KITITAS COUNTY

DEPARTMENT OF PUBLIC WORKS

MEMORANDUM

TO: All Staff
FROM: Public Works Plan Review Team
DATE: March 25, 2026
SUBJECT: BL-26-00003 Hanson

- Proposed
- Site Plan

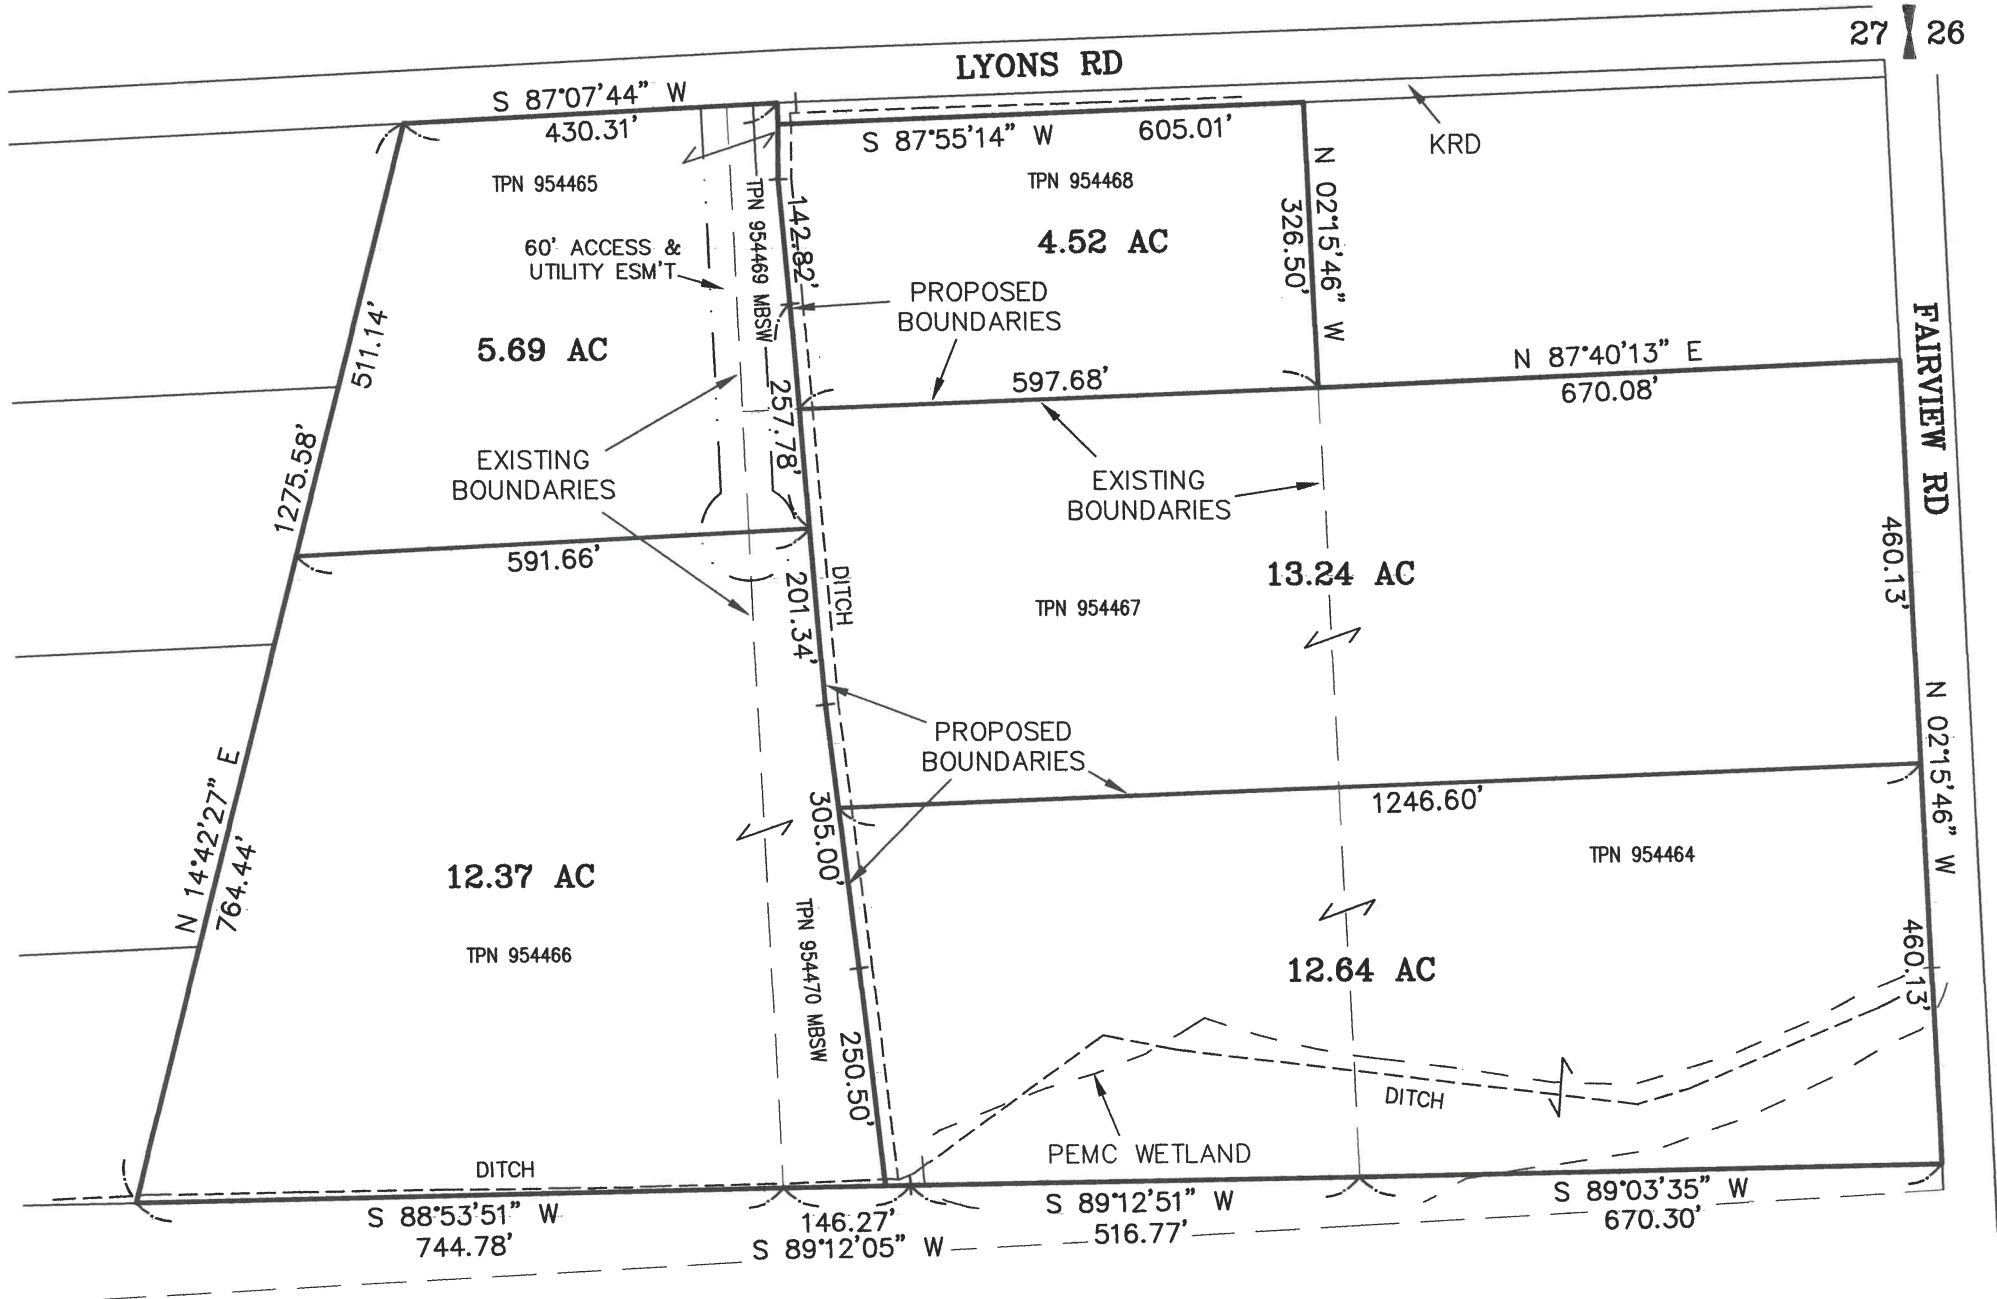
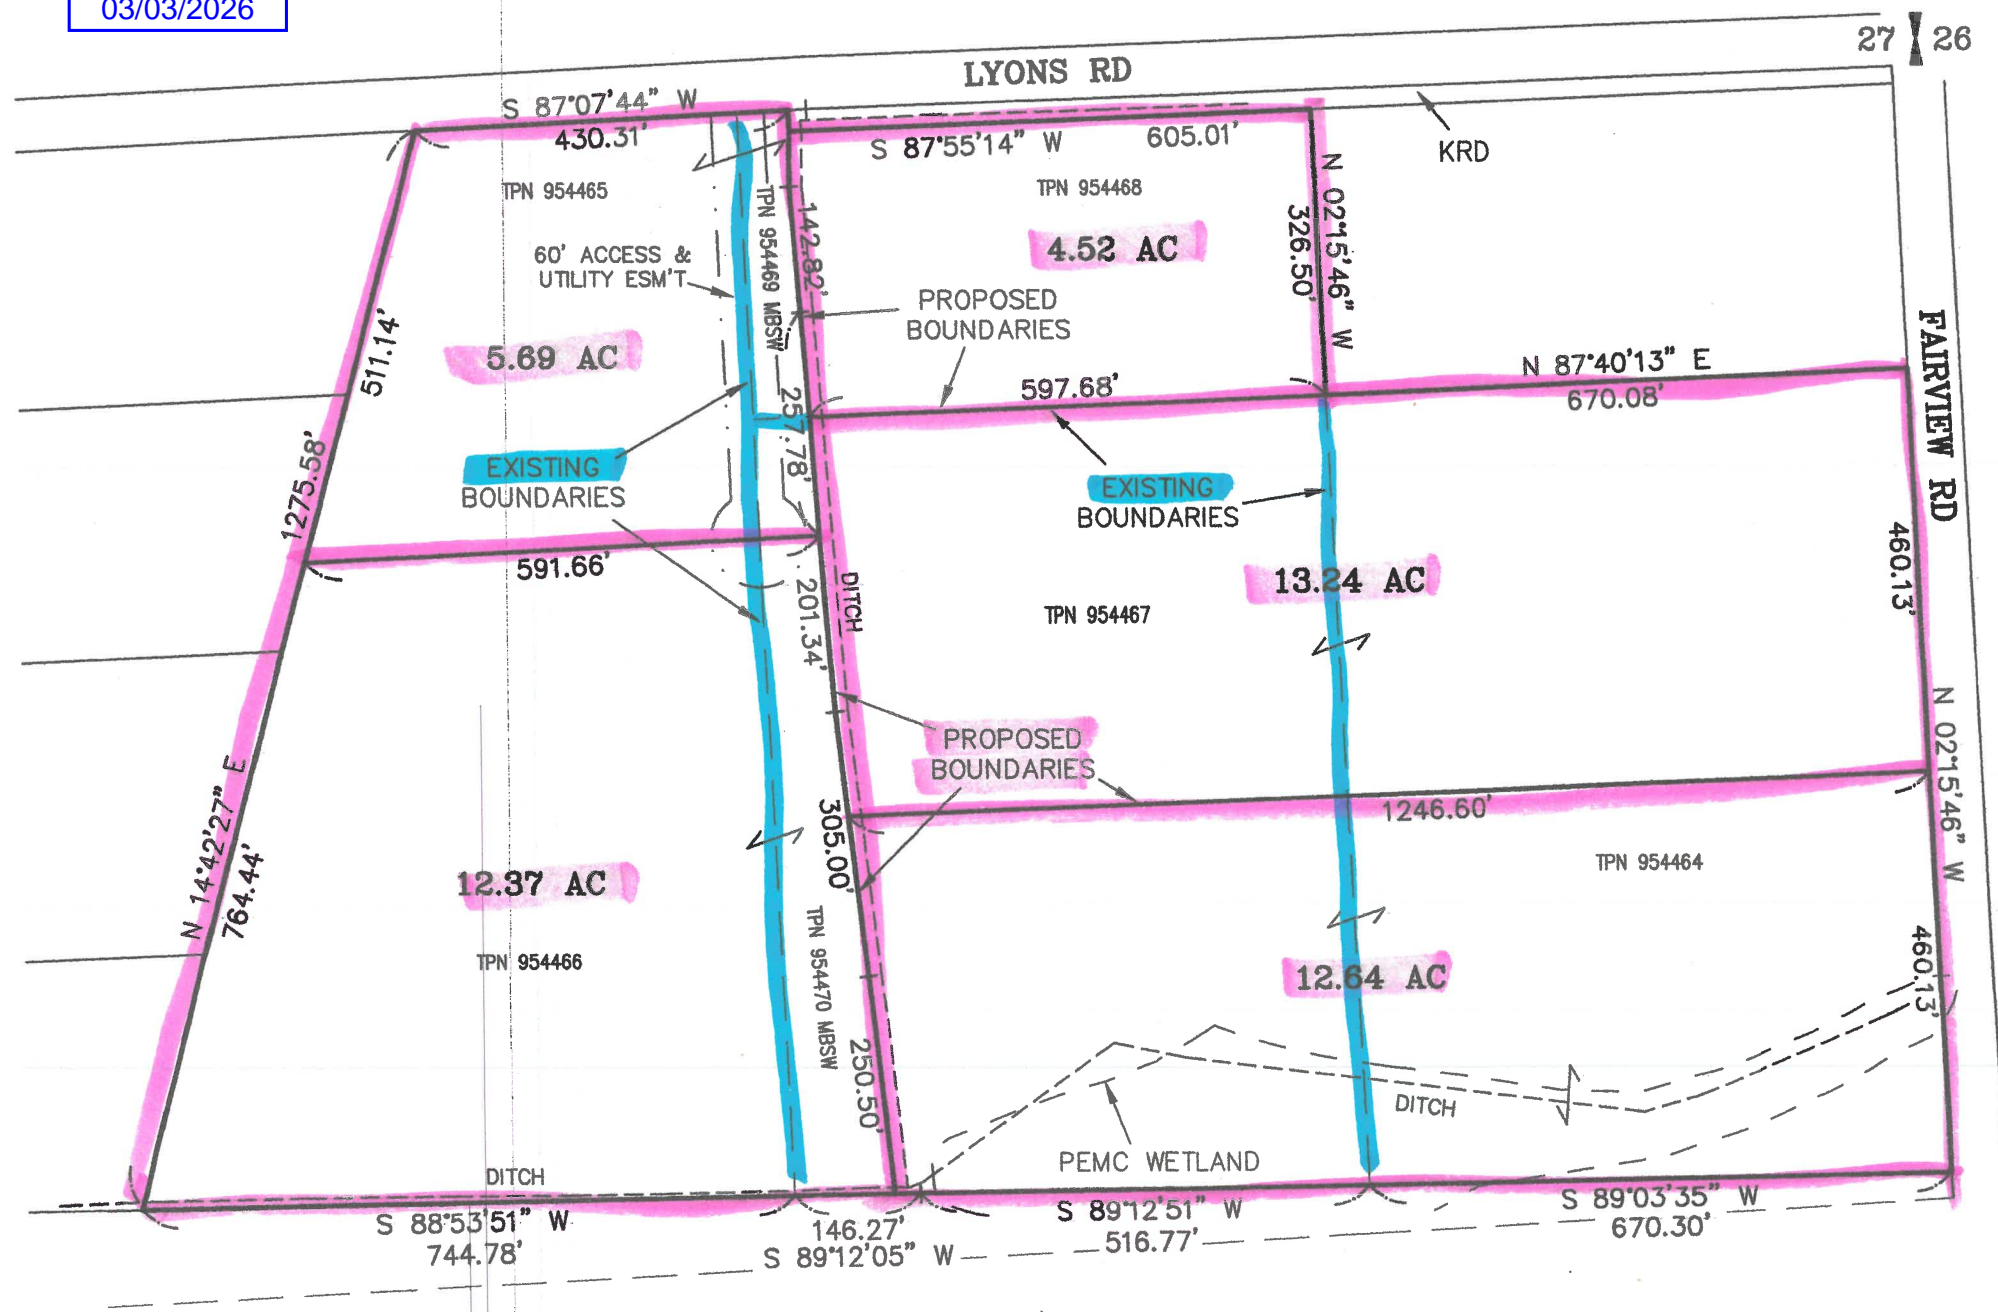
ACCESS	<ol style="list-style-type: none"> 1. Provide easements for access to lots from joint-use driveways. Lyons Road and Fairview Road have an access spacing of 300 feet between driveways on the same side of the road. 2. An approved access permit shall be required from the Kittitas County Department of Public Works prior to creating any new driveway access or altering existing access. 3. Maintenance of driveway approaches shall be the responsibility of the owner whose property they serve. The County will not maintain accesses. 4. Any further subdivision or lots to be served by proposed access may result in further access requirements. See Kittitas County Road Standards. <p>In addition to the above-mentioned conditions, all applicable Kittitas County Road Standards apply to this proposal. Access is not guaranteed to any existing or created parcel on this application. (RC)</p>
ENGINEERING	Except as exempted in KCC 14.05.060, no grading or filling upon a site involving more than one hundred (100) cubic yards shall be performed without a grading permit from the County Engineer or Public Works designee (KCC 14.05.050). An application for grading in excess of five hundred (500) cubic yards shall be accompanied by an engineered grading plan (KCC 14.05.080). (CBP)
